Final Report - Corrections Required **Application No. DEPN-26-0068**

Description : single family residential development with optional ADU. 41 lots

Document Filename : DP Creekridge at Flying Horse Filing No. 2 V2.pdf

JOB NUMBER	2786-0326
DATE	5/19/2026
DRAWN BY	MB
DRAWING DESCRIPTION	FINAL LANDSCAPE PLAN - OVERALL
SHEET #	L-1 7 of 14

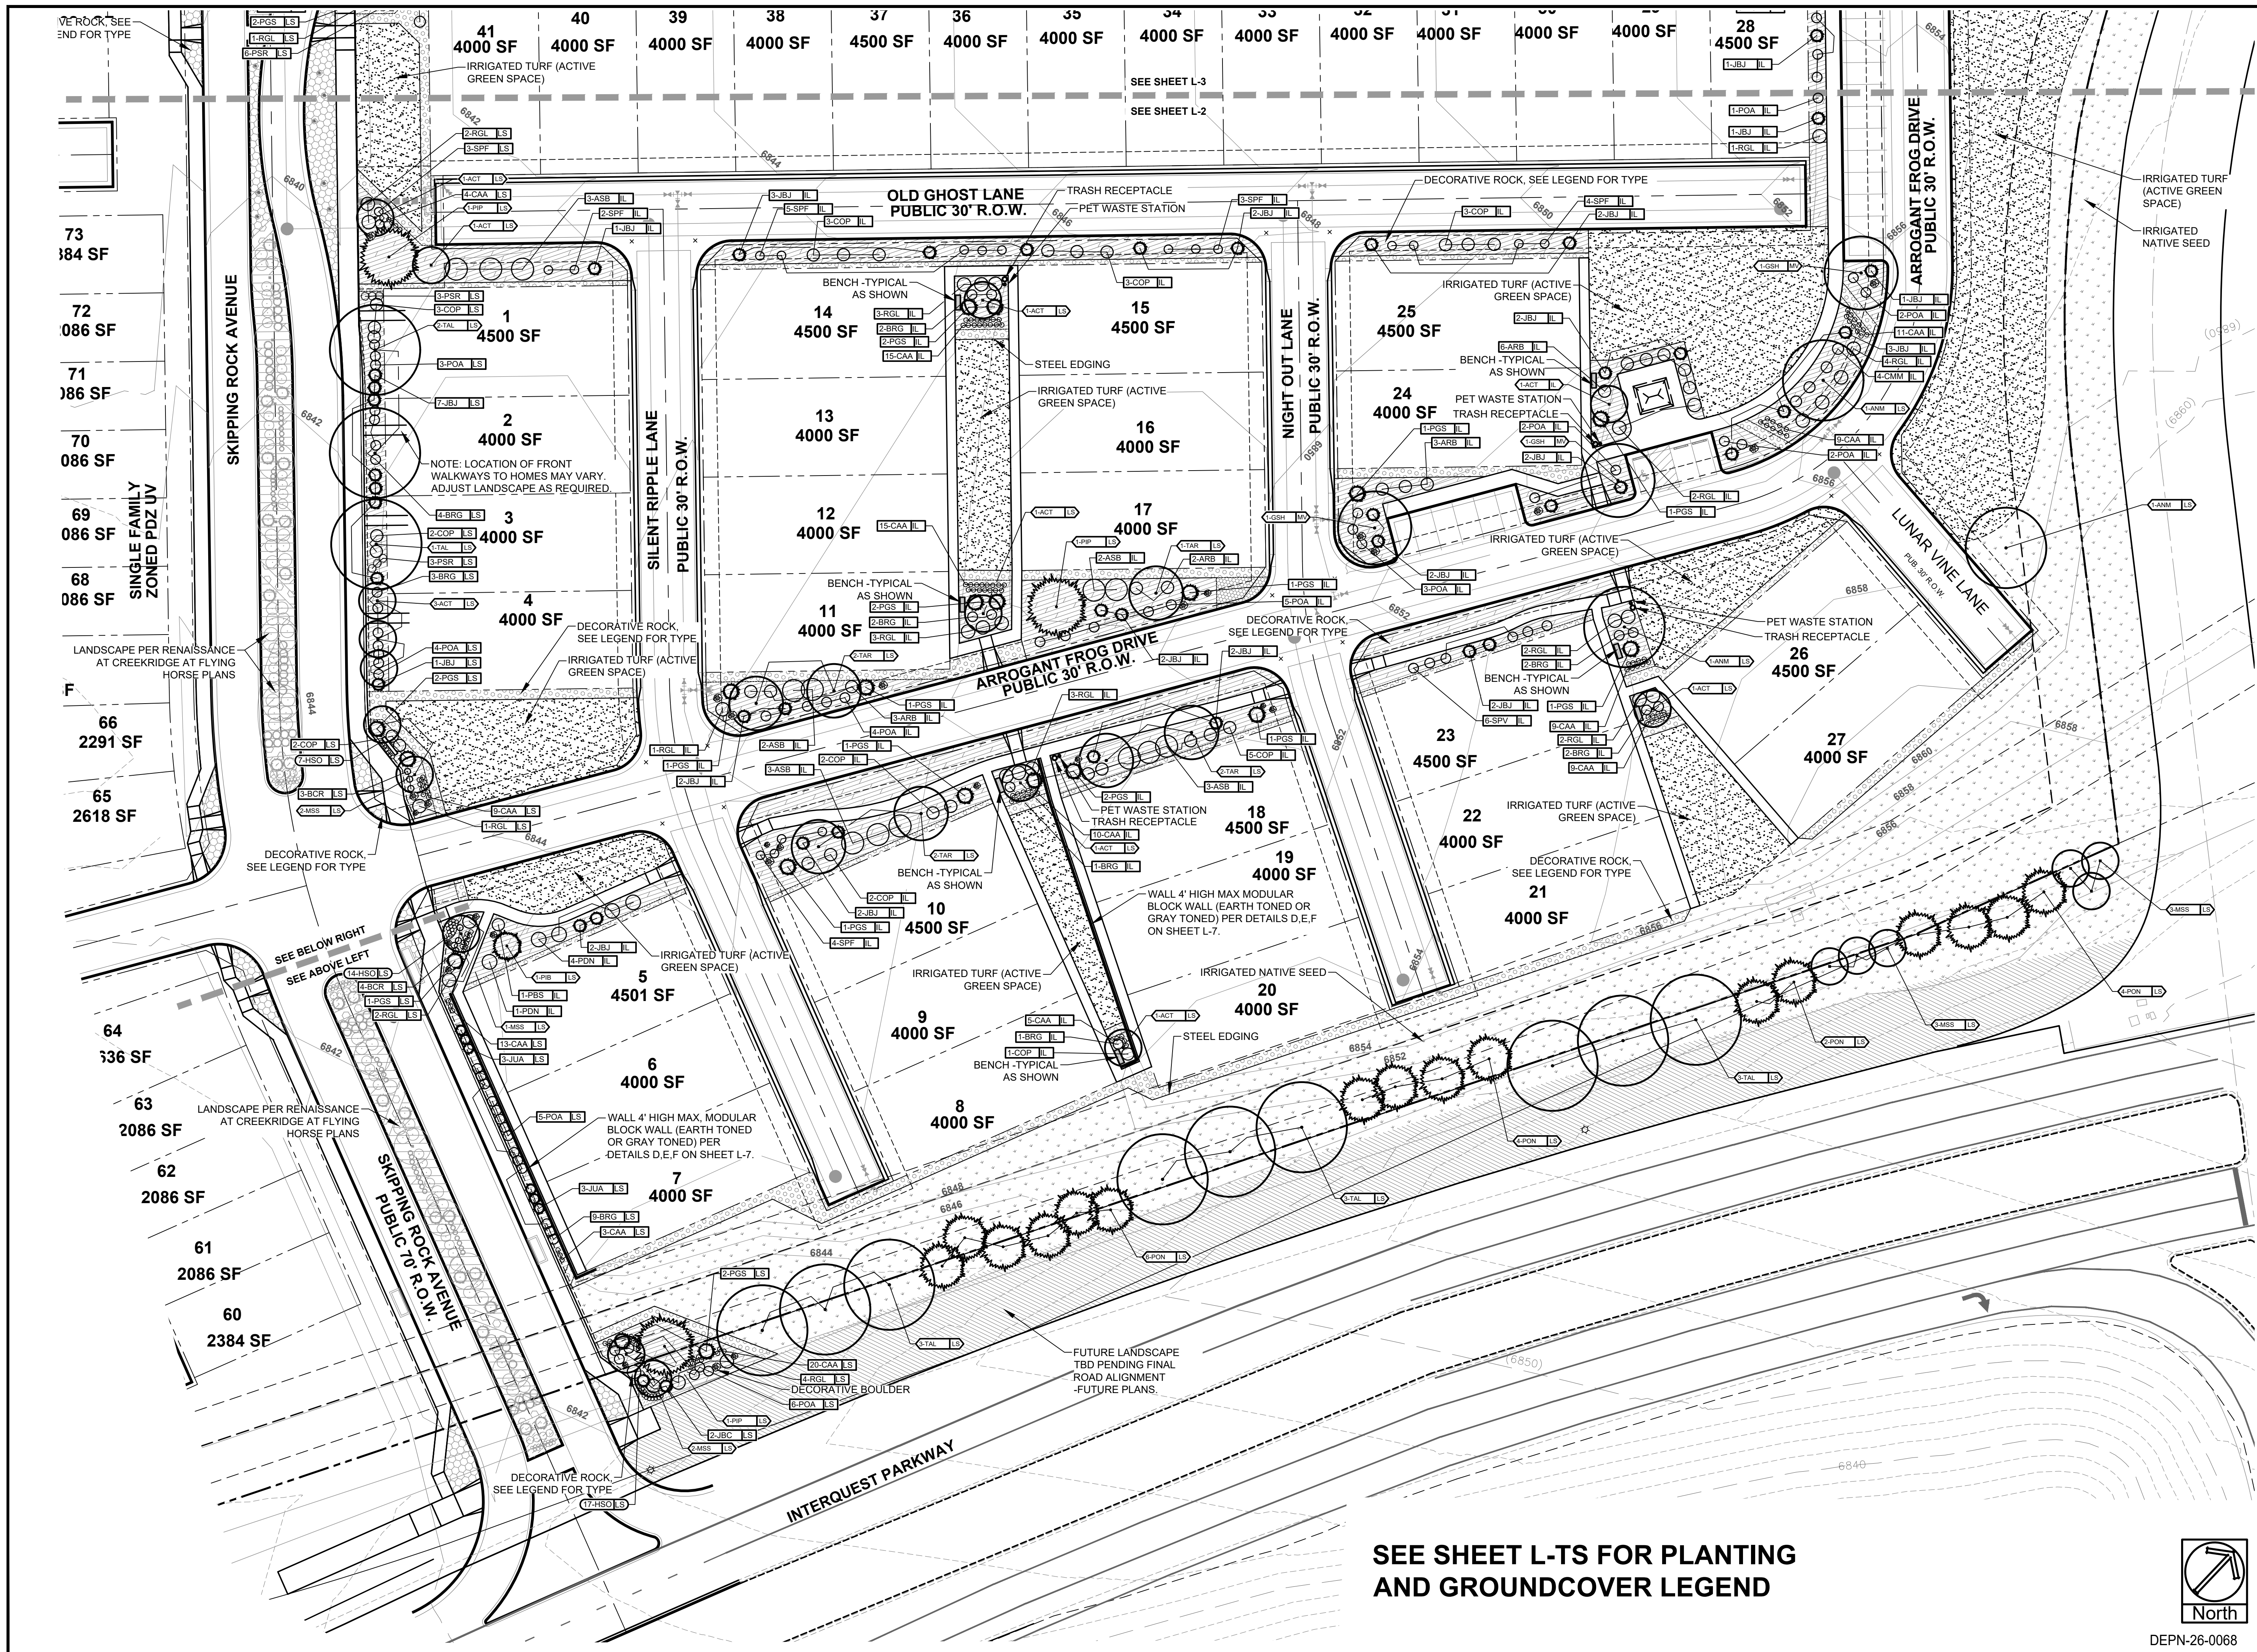
79	1	Allison Stocker : Planning	See follow-up comment on ADU parking
68	7	Gregory Stachon : Planning	Title page says "Preliminary Landscape Plan" please clarify
